CITY OF PORTLAND
STOP WORK NOTICE

June 20, 2001

RE: 696 Allen Ave.
CBL: 398-A-035

TYPICAL FOUNDATION WALL SECTION - MAIN HOUSE

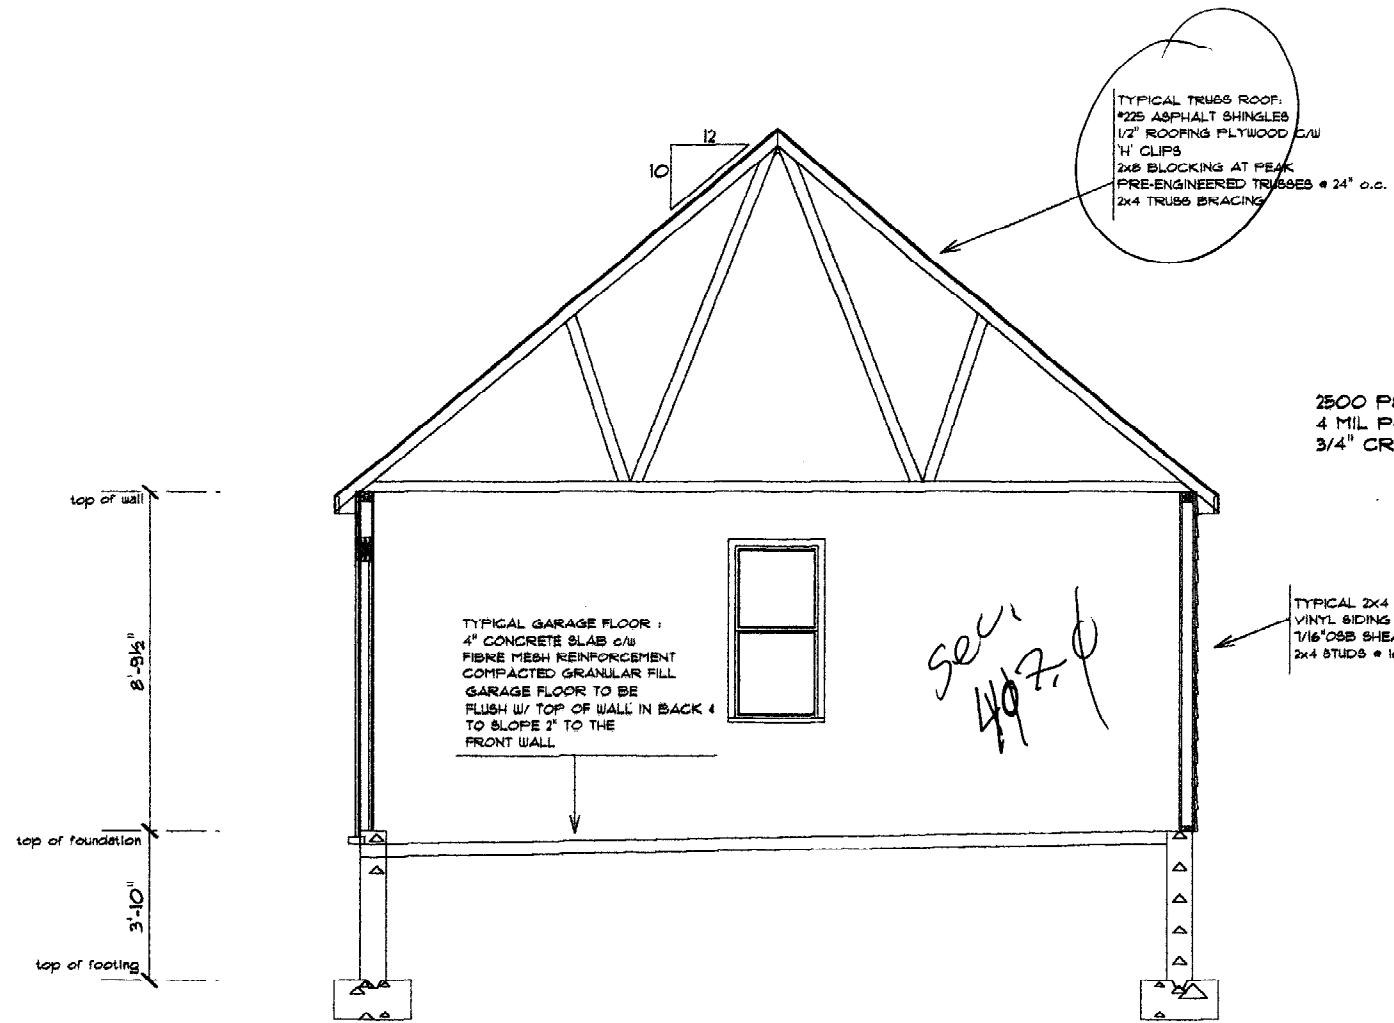
Plans provided do not match foundation as placed.
